## Andrew Beattie - Berry Equestrian centre

### **The Issues Associated with the Design of the Proposed Relocation of the Berry Equestrian Centre**

This submission concerns the impact of the proposed Foxground and Berry Bypass on the Berry Equestrian Centre which is located in North Street Berry.

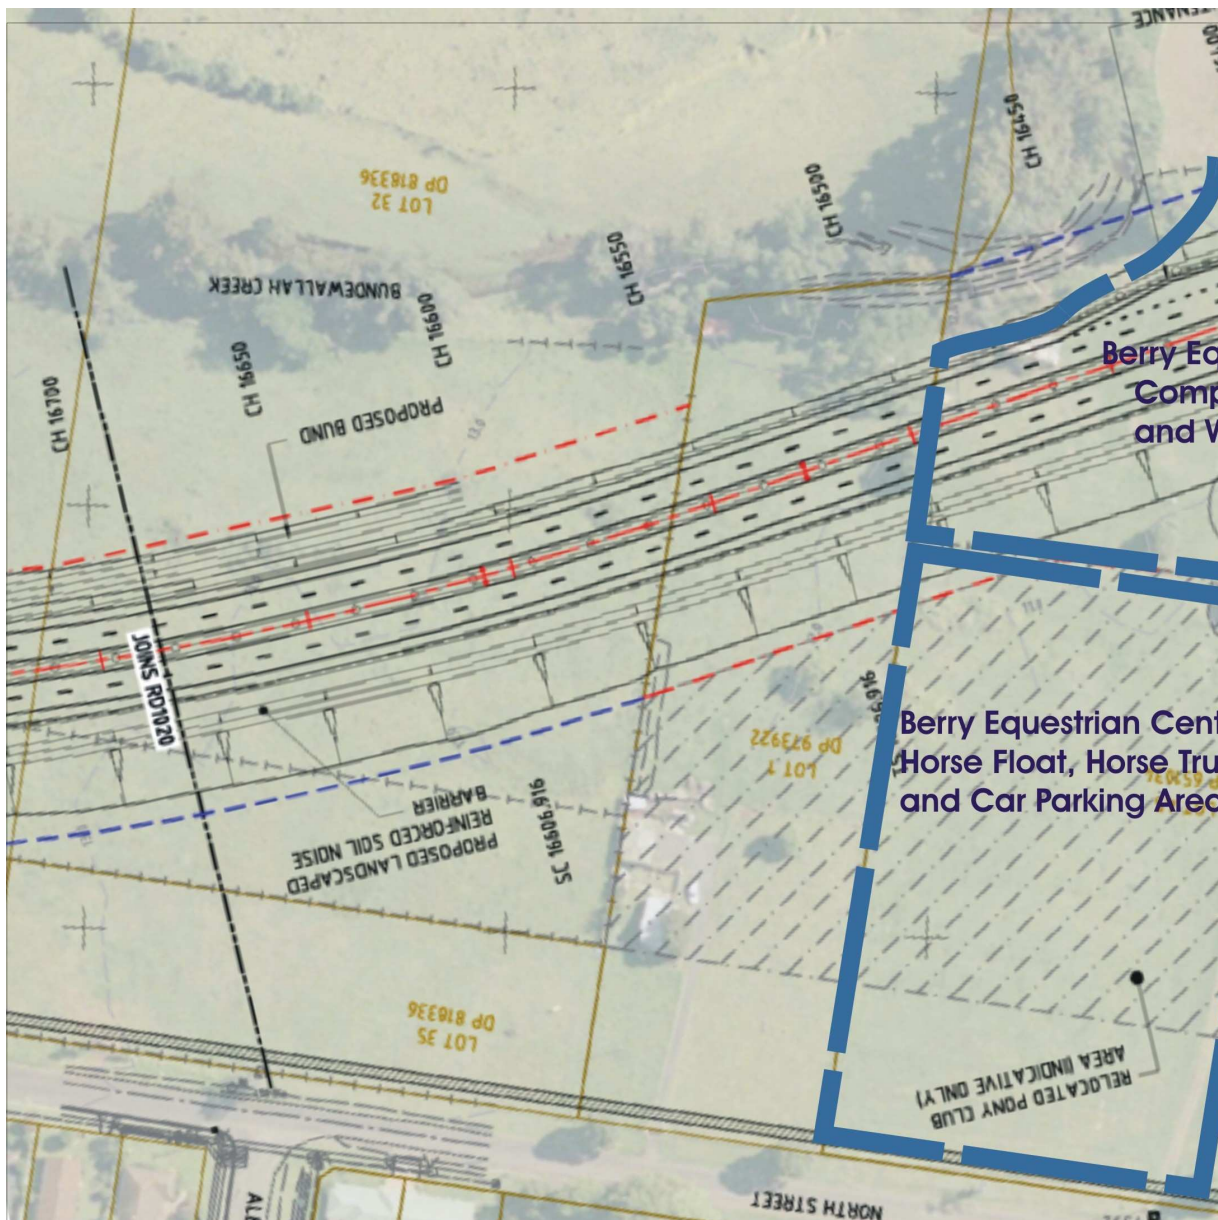
1. The competition grounds are required to be rectangular /square in shape of a minimum size of 140 metres x 140 metres with a level, well drained, good riding surface in order to cater for at least 4 dressage arenas or 2 showjumping arenas.

2. The parking area is required to be of a minimum area equivalent to 90 metres x 160 metres and allow for easy entry, maneuverability, parking and exit of horse floats and trucks. Each parking space is equivalent to an absolute minimum of 4 normal vehicle spaces due to the need for unloading/loading and tie up areas for horses.

3. There is concern for the safety of horses, riders and the general public due to the near location of the proposed riding area to the 4 lane expressway, the skateway, the public cycleway/walkway and North Street. There will be anticipated significantly increased noise and visibility of cars and trucks travelling at 100km/hour on the expressway with horses competing nearby, often with young, very inexperienced riders.

4. Access to the grounds is likely to be across a public shared cycleway/pathway. The safety of children on skateboards, bicycles etc are at risk as horse trucks and floats cross the pathway. Horse floats and trucks also require an indented driveway of at least 15 metres to allow vehicles to park off the roadway whilst gates to the grounds are opened.
